re: **Response to City Comments**
 Proposed Residential Development
 2710 Draper Avenue - Ottawa

date: July 22, 2019

file: PG1630-MEMO.25

Stone Strong Retaining Wall Design, Proposed Retaining Wall

Drawing file: plan / All_Image Referencing_Site Plan Application_Image Reference_2019-08-15 - Stone Strong Retaining Wall Plan - D07-12-18-0184.PDF

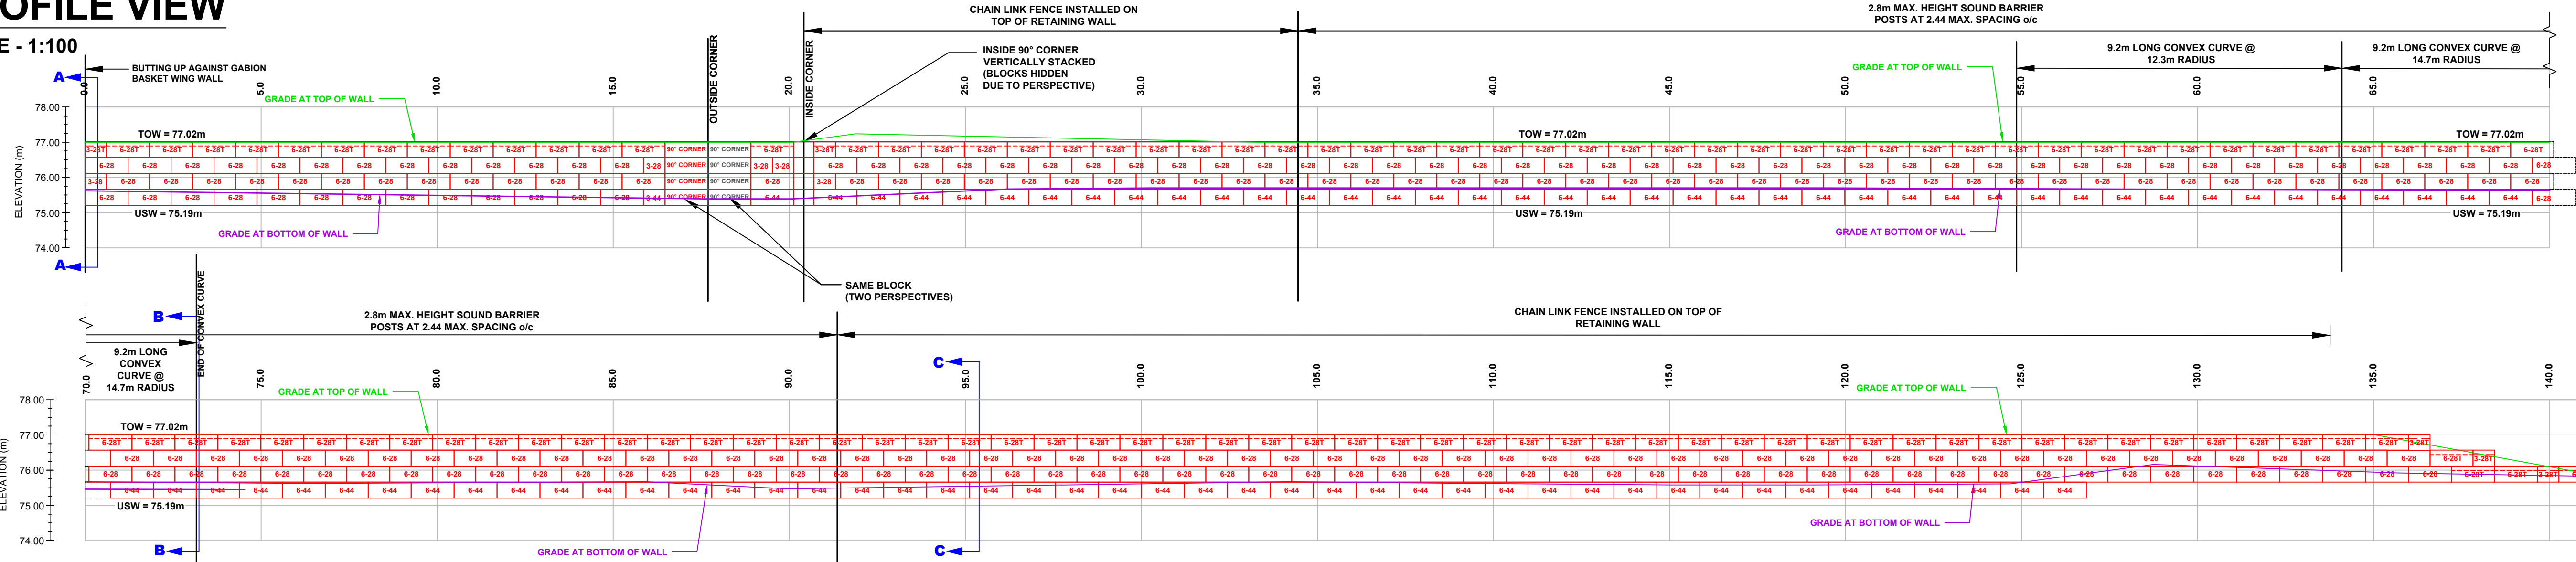
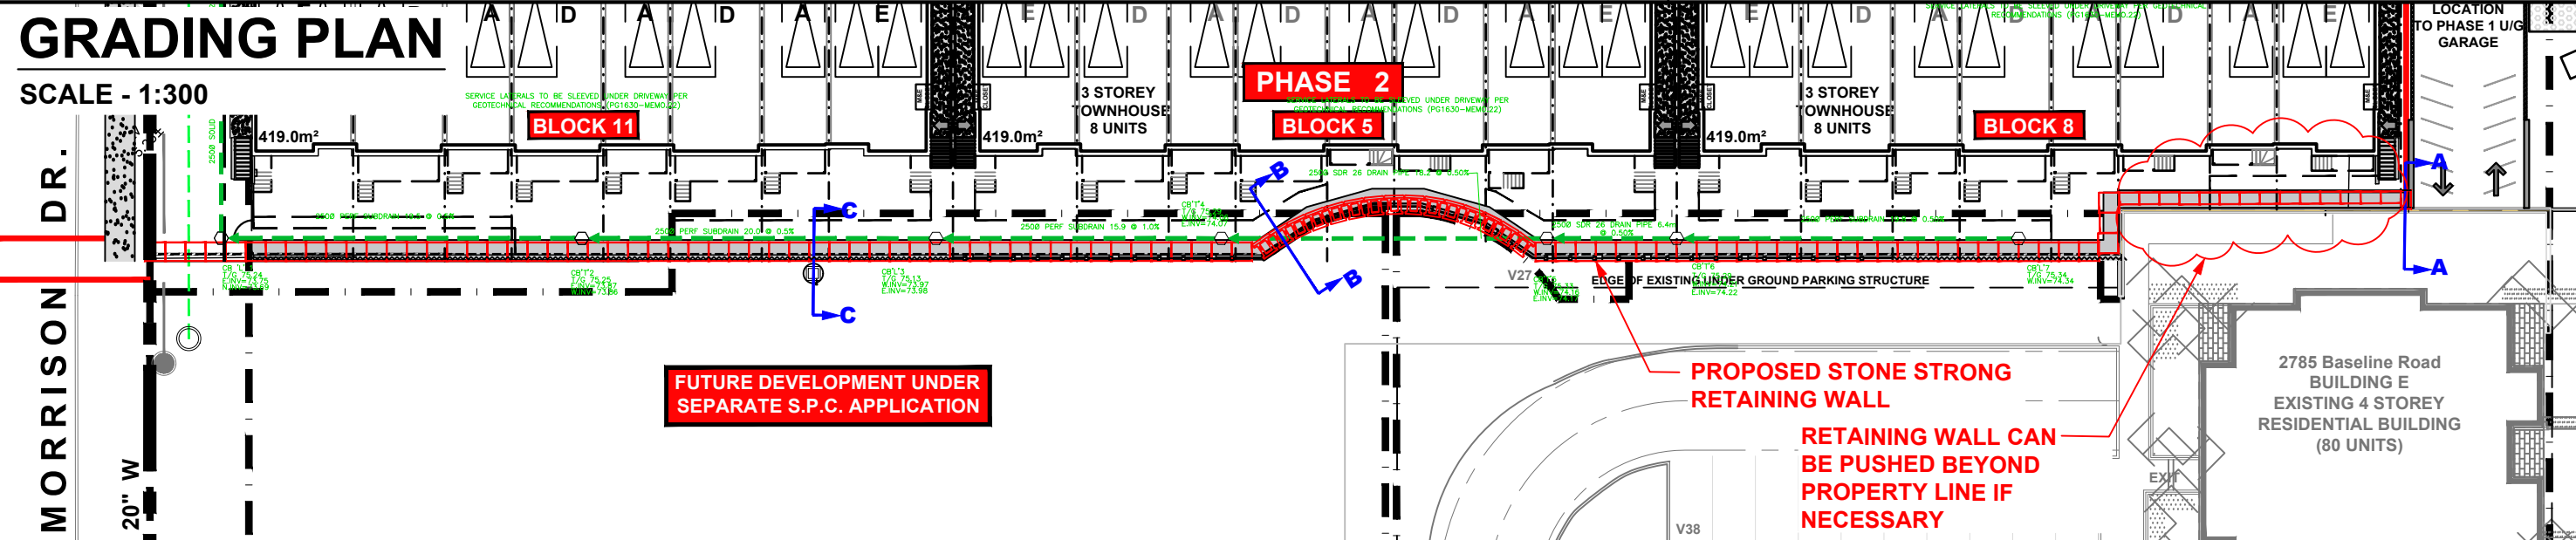
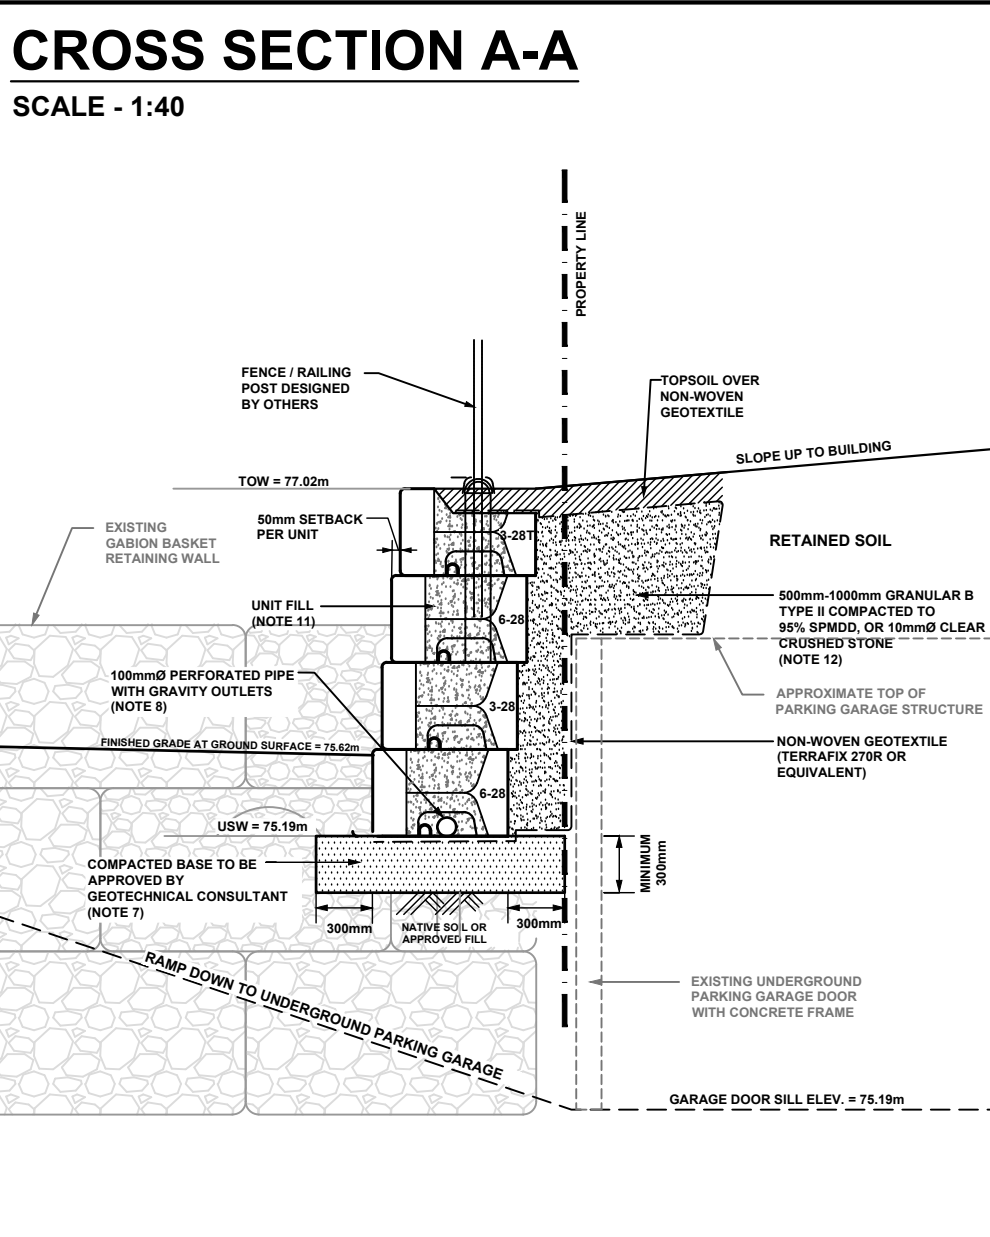
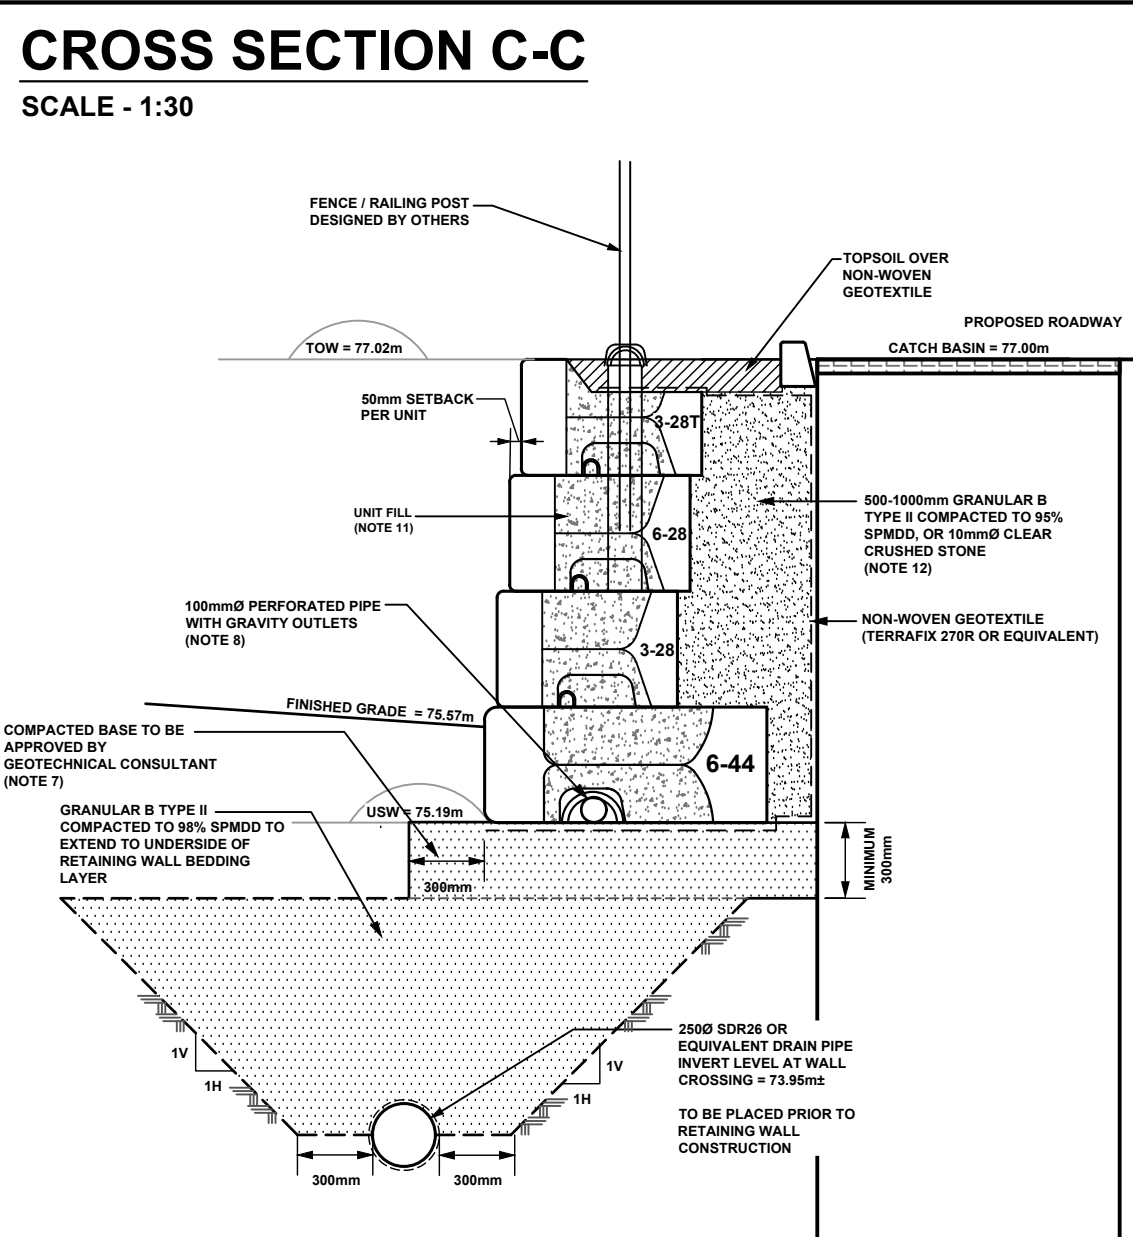
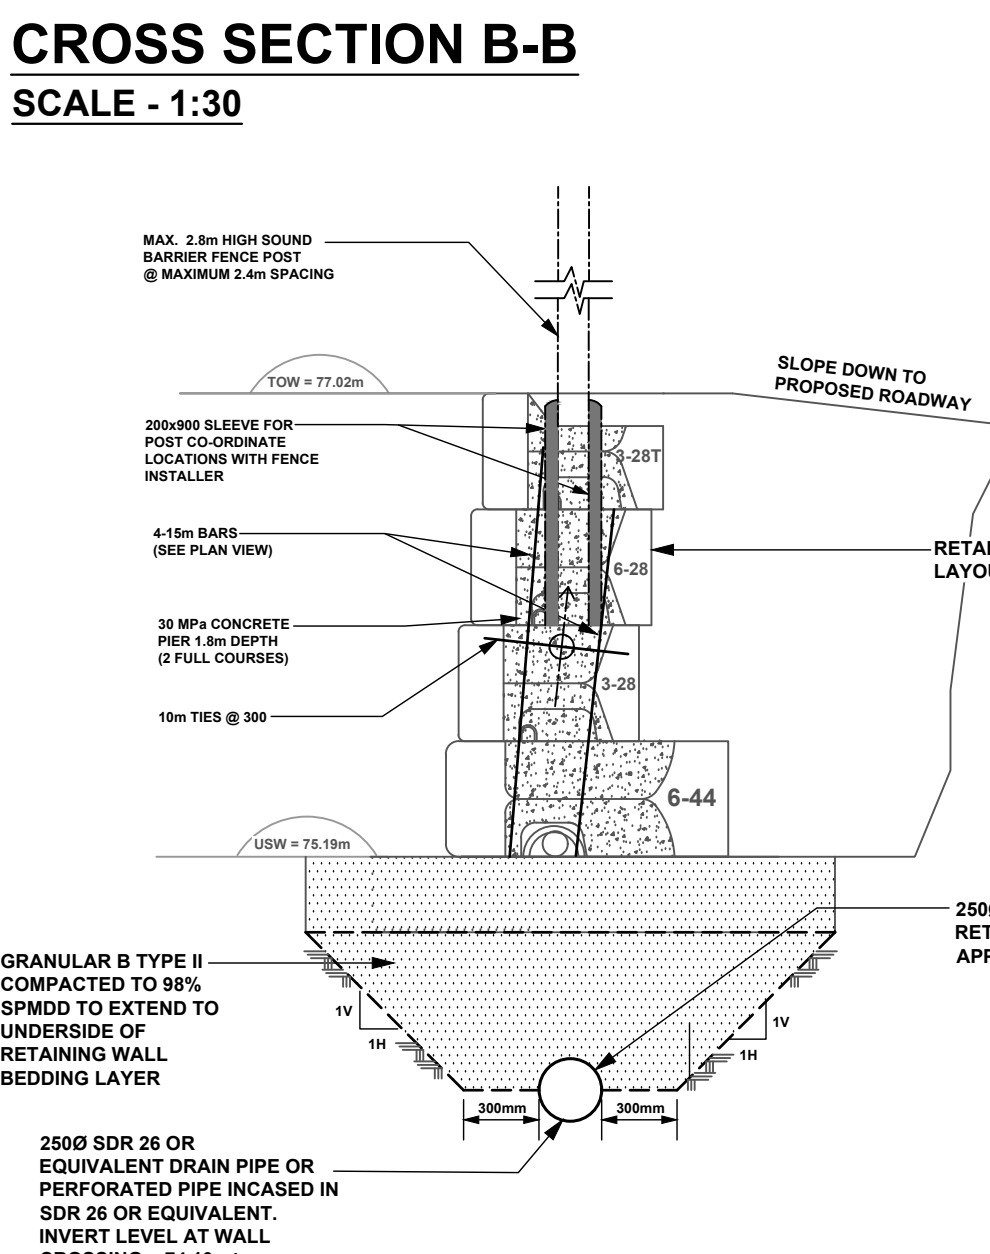
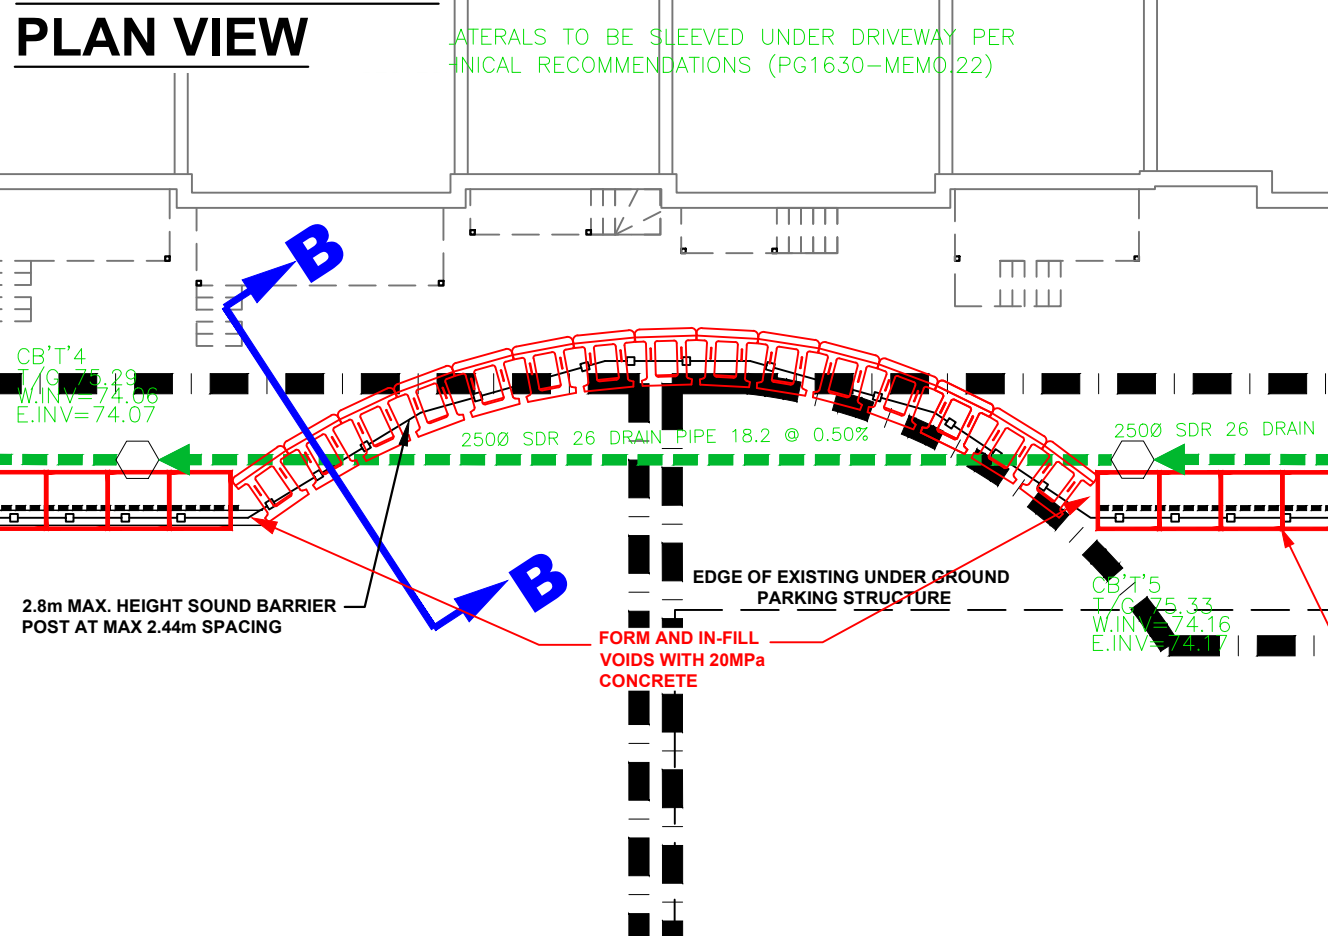
Comment 12: *As per an email from Jessica D'Aoust (Lloyd Phillips & Associated Ltd.) Dated June 21, 2019 the intention is for the proposed stone strong retaining wall to follow the property line and go around the future "turning circle" at the rear of Block 5. The current proposal does not have the retaining wall following the property line as it is going through the "turning circle". Please discuss with Lloyd Phillips & Associated Ltd. And update the stone strong retaining wall design accordingly.*

Response: Stone Strong Retaining wall design was updated to follow property line and future turning circle.

Comment 25: *The rear-yard drainage proposal does not respect the current property line as minor and major system flows are proposed to be conveyed across the condominium lands. As per an email from Jessica D'Aoust (Lloyd Phillips & Associated Ltd.) Dated June 21, 2019 the intention is for the proposed stone strong retaining wall to follow the property line at the rear of Block 5 in order to allow for a future "turning circle" in order to maintain the original approved design for the condominium lands. If this is the intention the rear yard drainage system will be compromised and therefore will have to be designed and will be subject to additional reviews. If the intention is to proceed with the traffic circle to maintain the original approved design for the condominium lands which will require additional modification to Phase 3-2 lands it shall be communicated to DSEL to ensure the rear yard drainage system is design accordingly otherwise it will be difficult to accommodate such changes at a later date. The perforated pipe will not be permitted to be installed below the retaining wall.*

Response: From a geotechnical perspective it is acceptable for the proposed drainage to pass under the proposed stone strong retaining wall provided that SDR Grade 26 or equivalent is used where the drainage is crossing under the wall and the future turning circle. Alternatively, the perforated sub-drain pipe can be encased in a SDR Grade 26 or equivalent pipe where crossing under the wall and the future turning circle. Please refer to our revised retaining wall design drawing PG1630-4 Revision 2 dated July 18, 2019. The installation of the sub-drain pipe can rear yard catch basin will have to be completed prior or at the time of wall construction to avoid undermining the precast block units.

SOUND BARRIER DETAILS

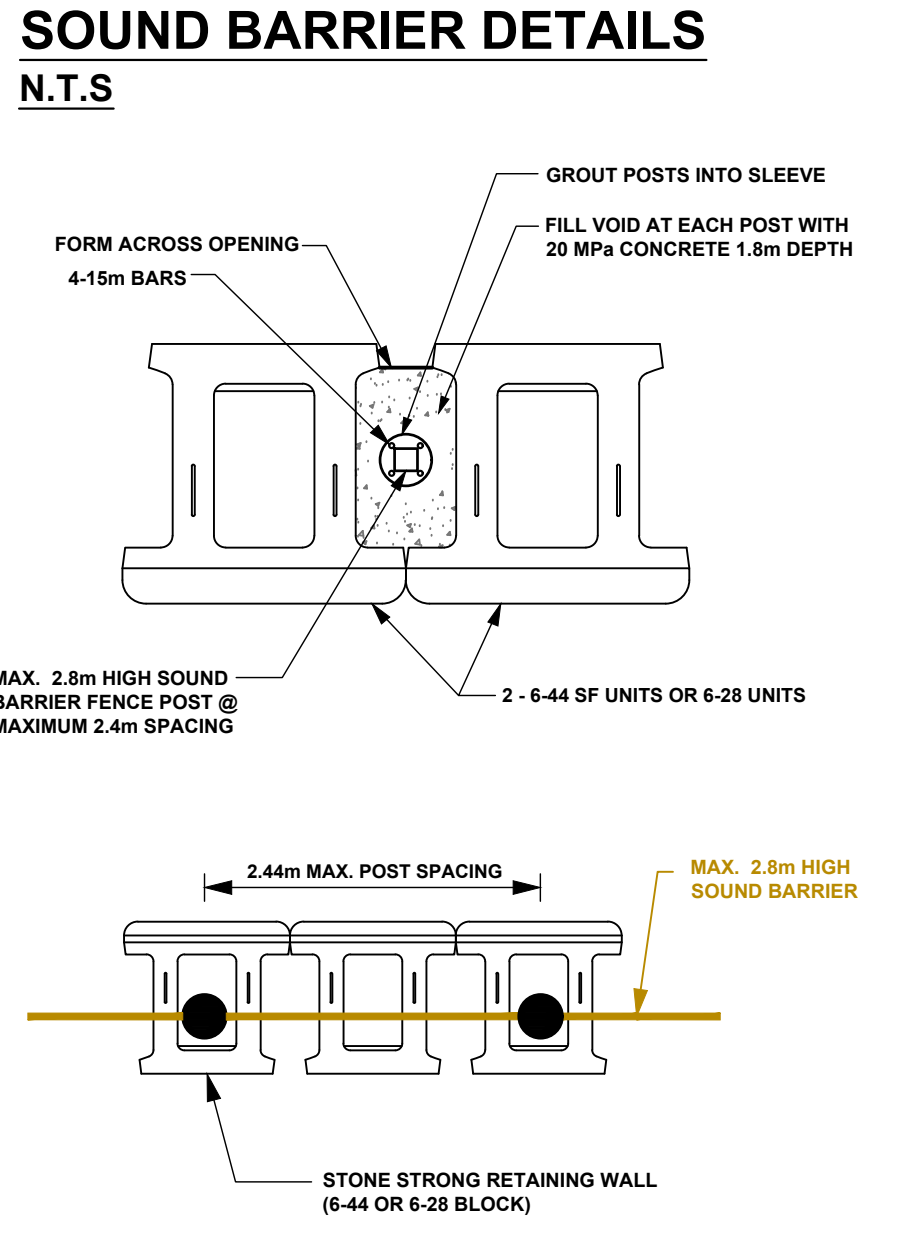
Comment 14: *Please document on the plans the noise wall proposed along the top of the wall as per the Gradient Wind Traffic Noise Assessment.*

Response: The position of the proposed sound barrier was incorporated into the retaining wall design and comments have been noted for design and construction purposes. The extent of the noise barrier wall is also shown on the plan view in the referenced wall design drawing.
